Our Ref: 10/05790
Your Ref:09_0088

18 June 2013

**RE: MP 09_0088 Mixed Use Subdivision West Culburra
DG's Environmental Assessment Requirements.**

WEST CULBURRA MIXED USE CONCEPT PLAN

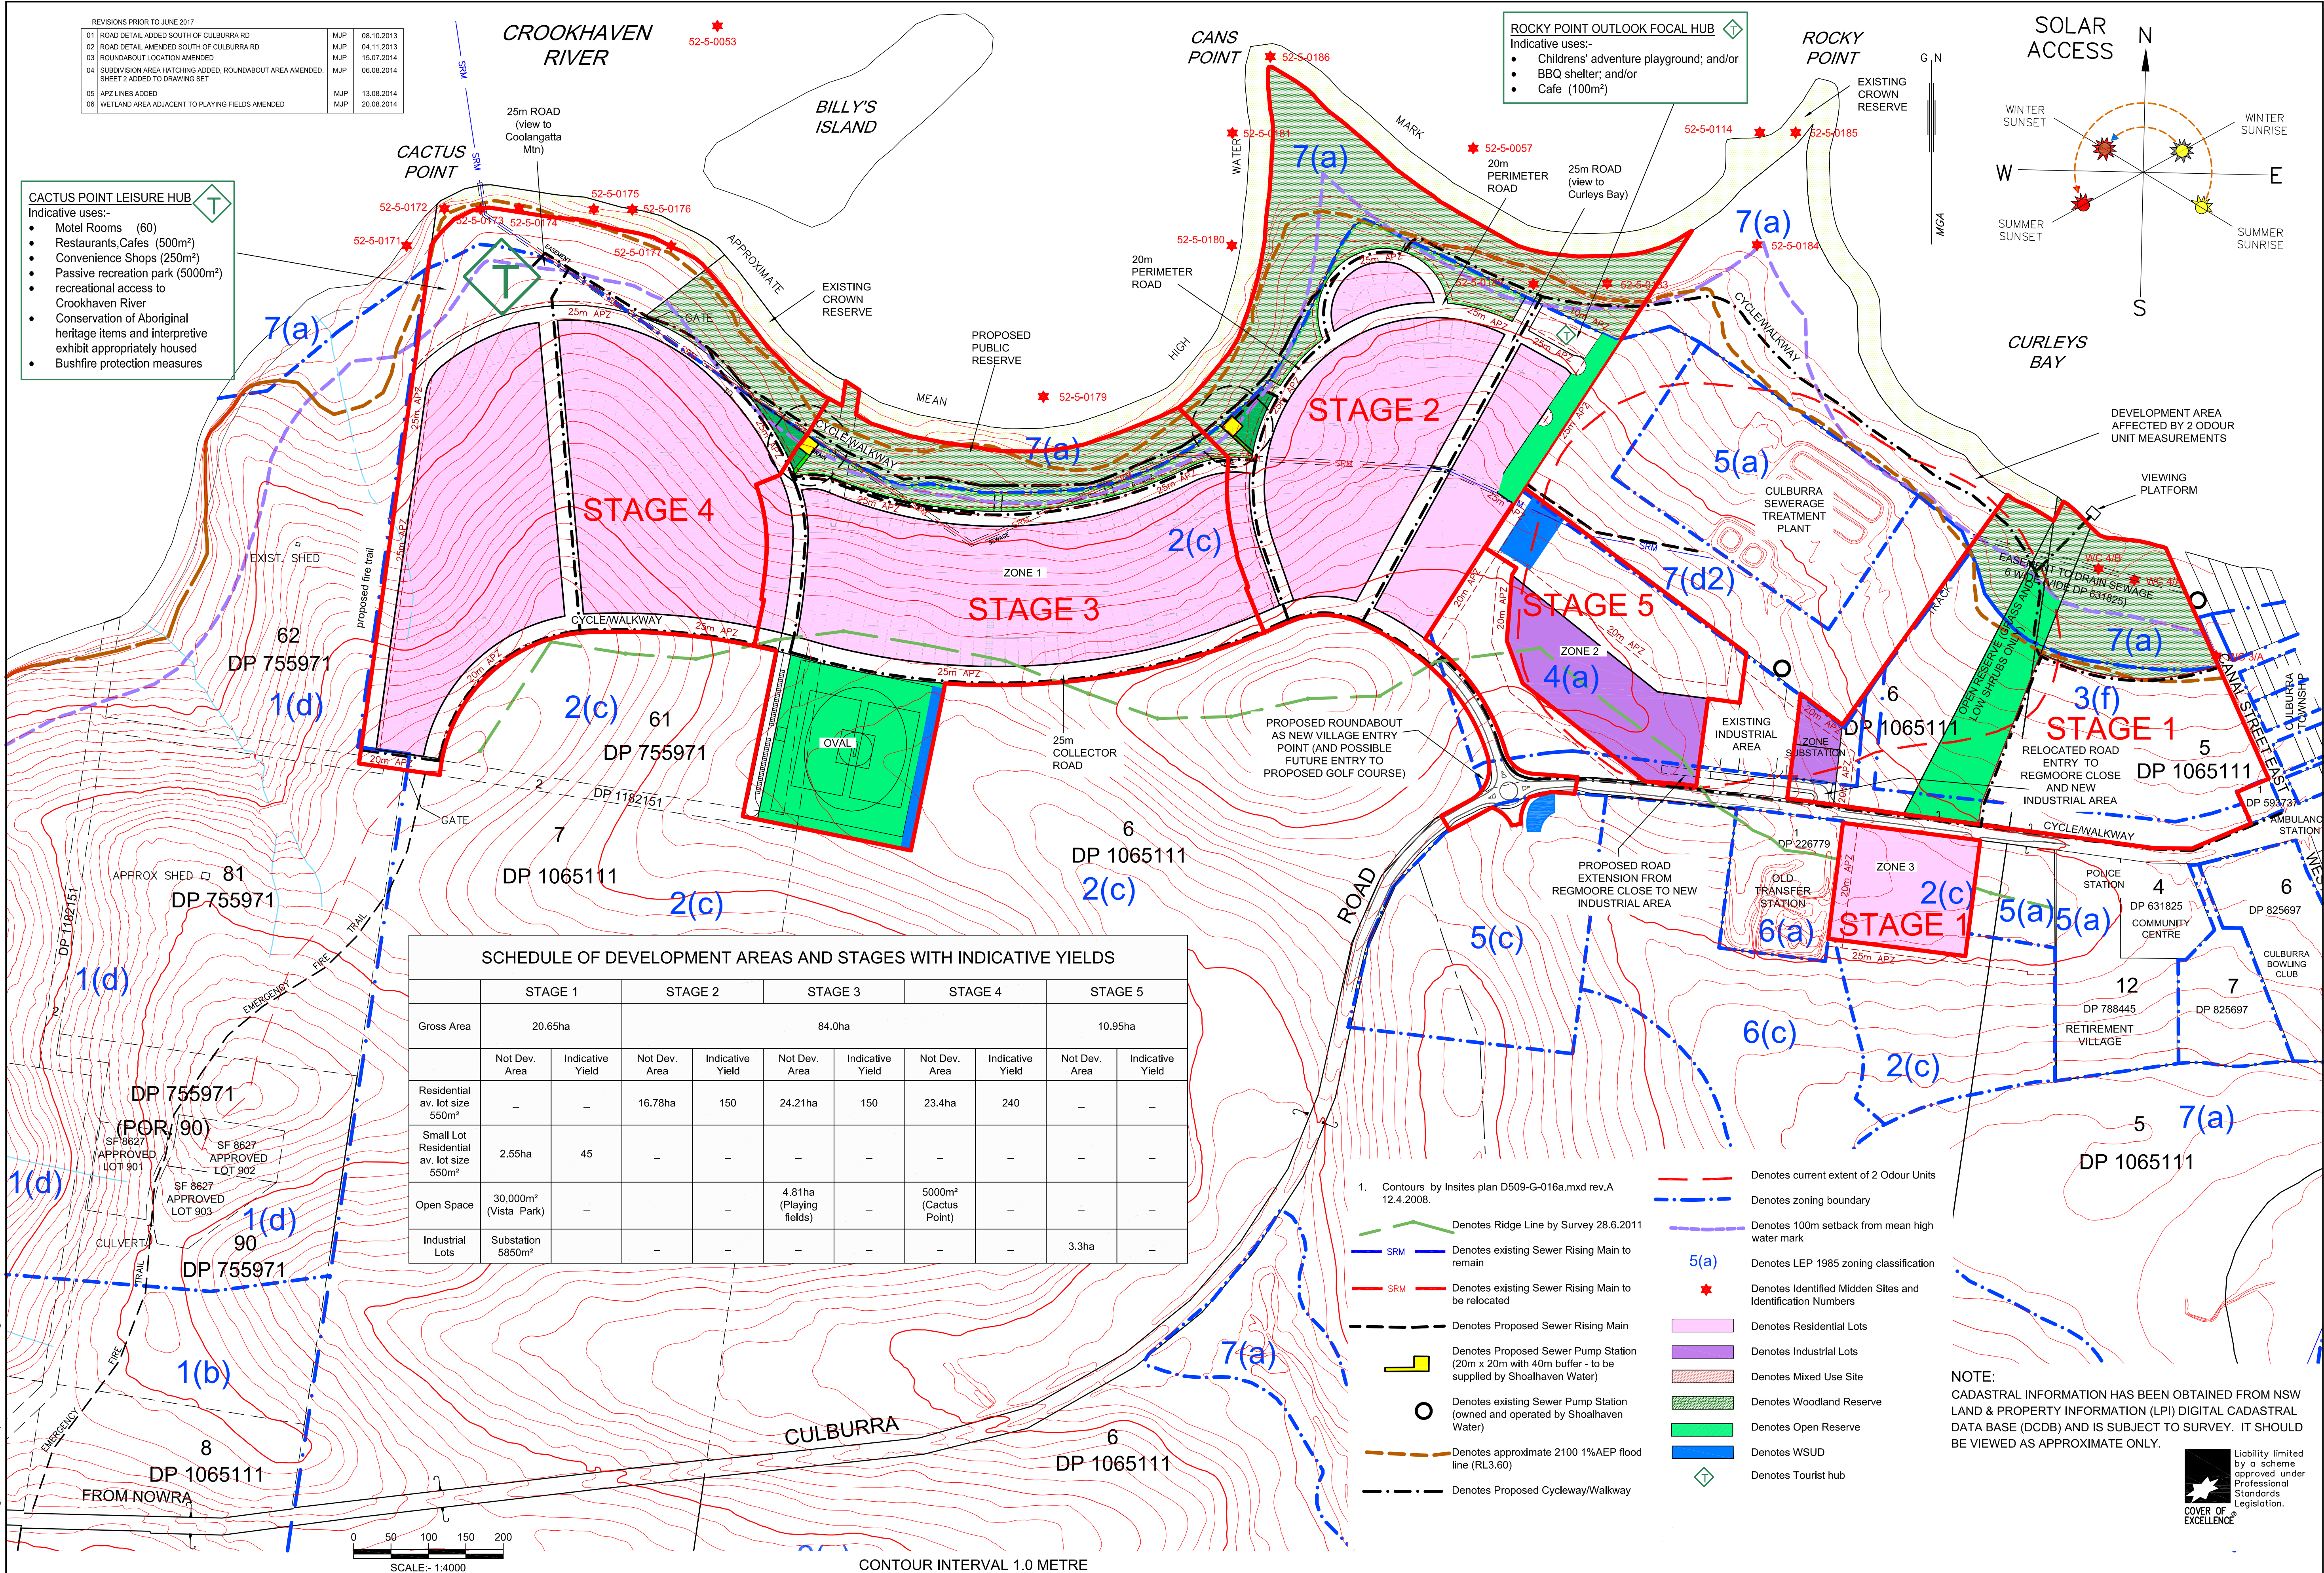
The EA does not accurately confirm the extent and purpose of any Crown land it is seeking to include in the proposed development, particularly in regard to a foreshore cycleway/walkway, clearing for views and development of boating facilities.

As per DG's requirements any proposed public infrastructure, including stormwater infrastructure, stormwater treatment areas, constructed wetlands, pipes, cycling/walking tracks or other utilities, are required to be located on private land and outside of any riparian corridors/ ecological buffers.

Prior to any development in the area of the Crown reserve, the boundary between the reserve and the adjacent freehold land must be physically defined to ensure infrastructure to service the development is contained within the freehold land to which the development applies.

The EA appears to propose that a boat ramp, jetty and associated infrastructure will be developed on and adjacent freehold Lot 61 DP 755971 in the areas of the 'western vista avenue', see Figure 1.

The boat ramp, jetty and associated infrastructure is not shown on the Concept Plan or referred to in the text, but does appear at Drawings 3 and 13, and within the Community Power Point Presentation as a zone of Economic Activity.

Notwithstanding the Crookhaven River being 400m wide from this point, the navigable channel is approximately 25m wide and is located approximately 240m from the proposed site of the boat ramp. The Crookhaven River at this location is often shallow and shoaling, is vegetated with a variety of Sea-grasses and contains DPI oyster growing leases.

The depth of water in the location at low tide is crucial to the ability even of small boats to use such a facility. Bathymetric survey should be undertaken to assist with determining the viability of any boat ramp or jetty proposed to be constructed on the Crookhaven River.
